From: TONY PHEBEY [REDACTED]
Sent: 10 September 2019 13:44
To: Finlay Gardner <Finlay.Gardner@arun.gov.uk>
Subject: RE: Application BR/178/19/PL

I have recently taken over your application BR/178/19/PL (Delawarr House, Flat 1). I am emailing with a few questions about the proposed plans. In the larger flat the bedroom appears to not have any direct access to daylight. Would there be a possibility of a window in the dressing room?
Any information you can give me will be greatly appreciated.

PROPOSED FIRST FLOOR PLAN/ROOF PLAN
Scale 1:50

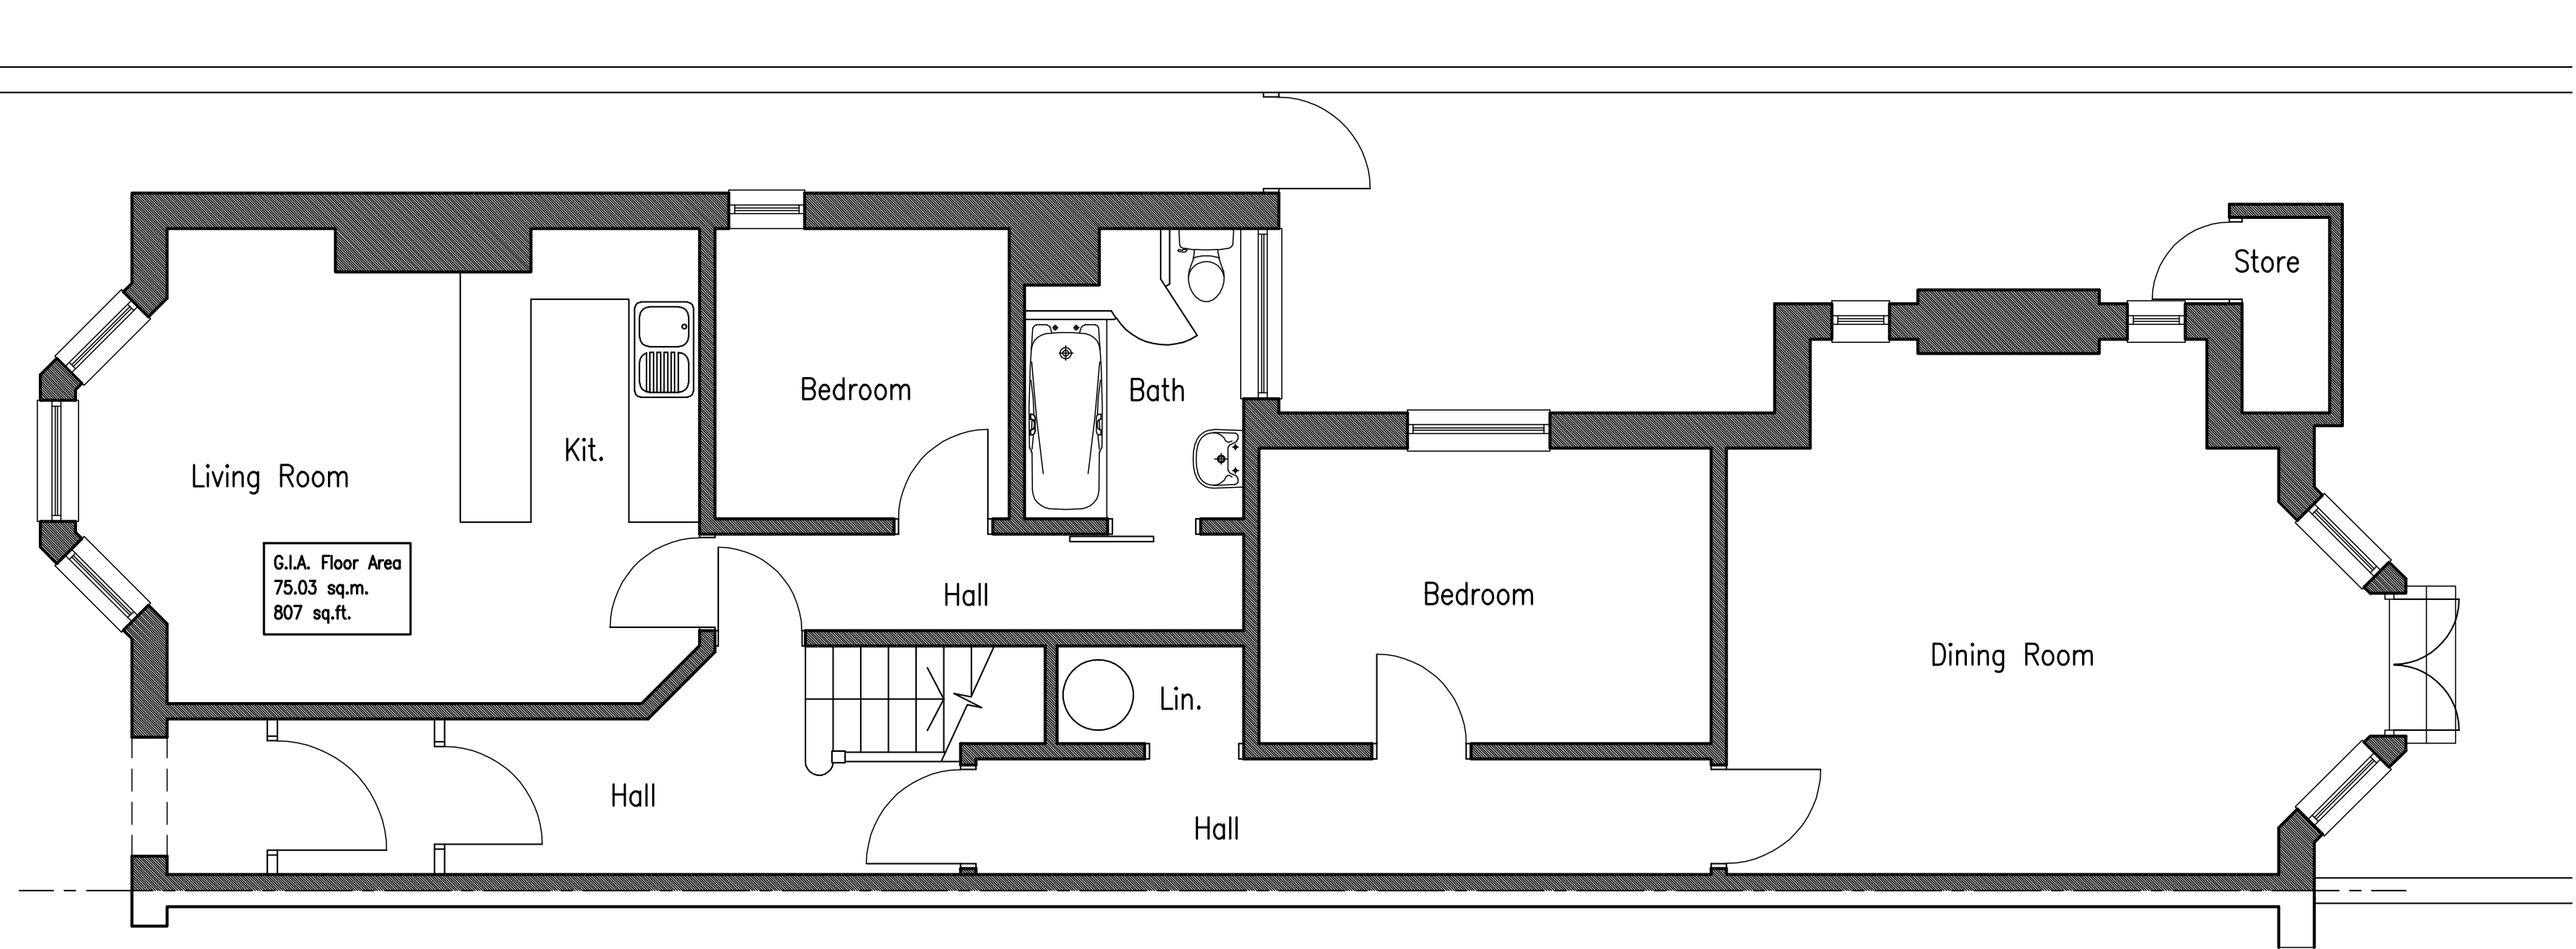
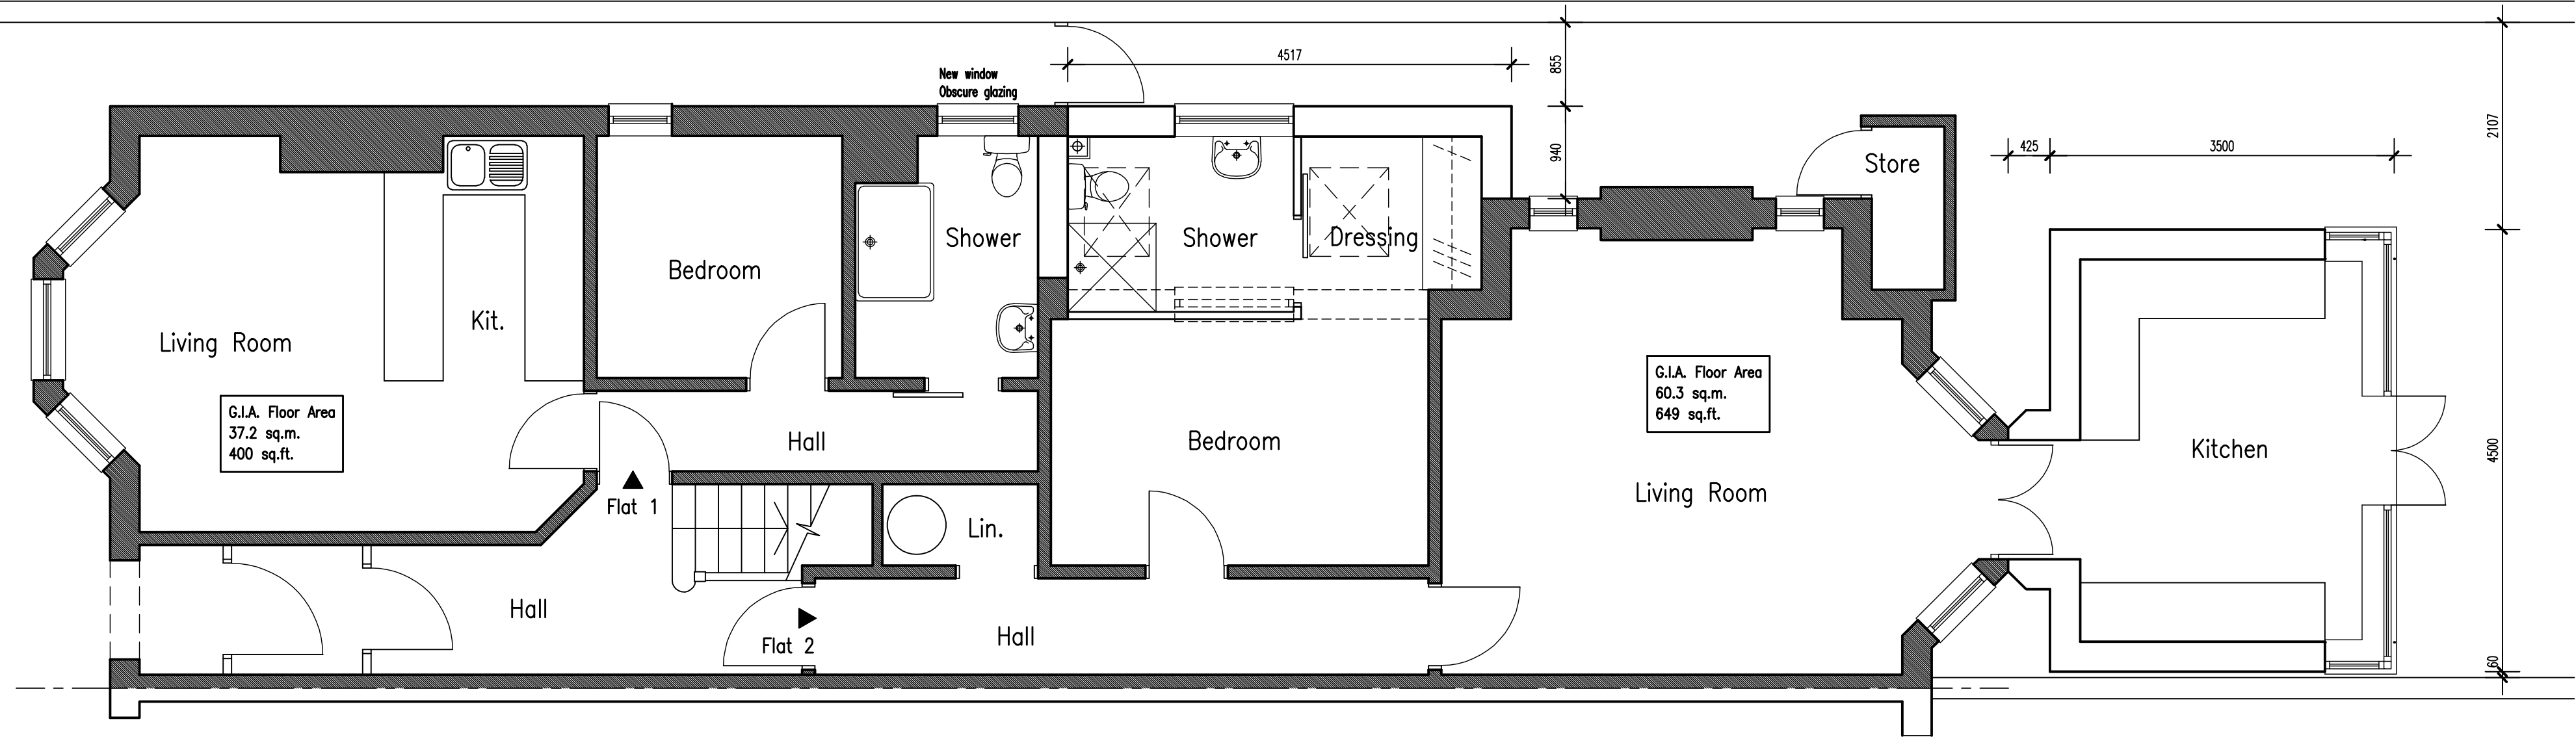
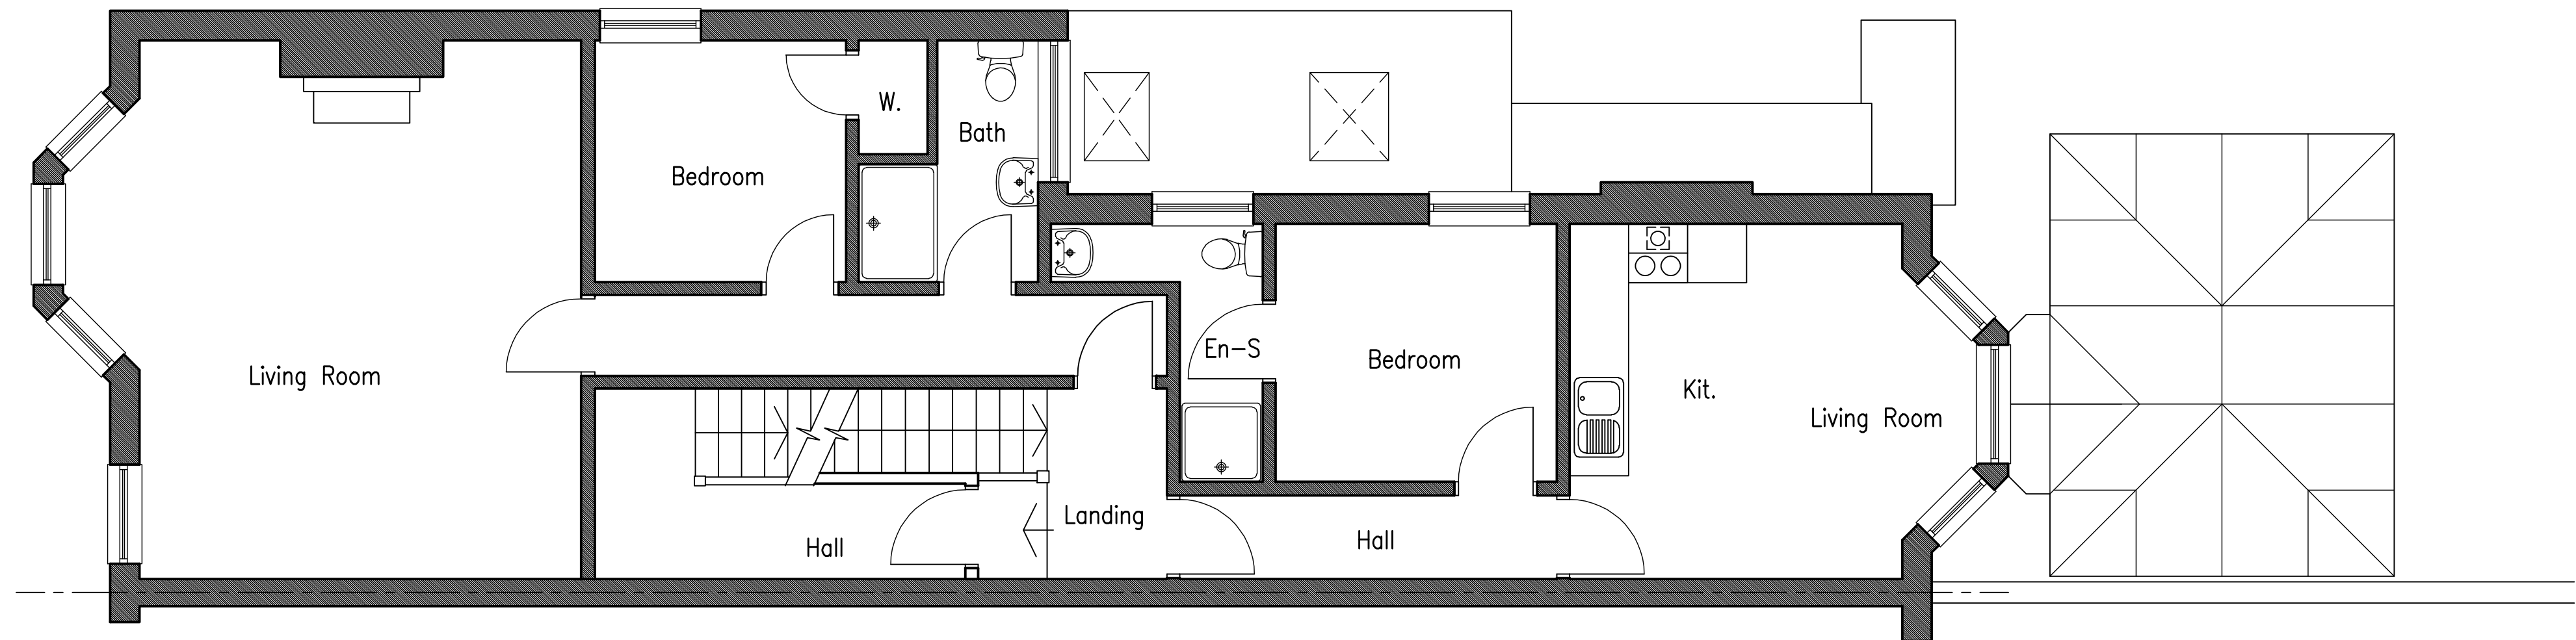
The issue that we find with the sky light is that it is not direct light into the bedroom, the way we would see to overcome this is to have a window in the dressing room, is this a possibility?

Further to your earlier e-mail please find attached amended planning drawings showing an additional window to the side extension bedroom as requested.

Further to your e-mail below I can confirm that the plans currently show a roof light to dressing room. I have attached the floor plans and elevations for your information.
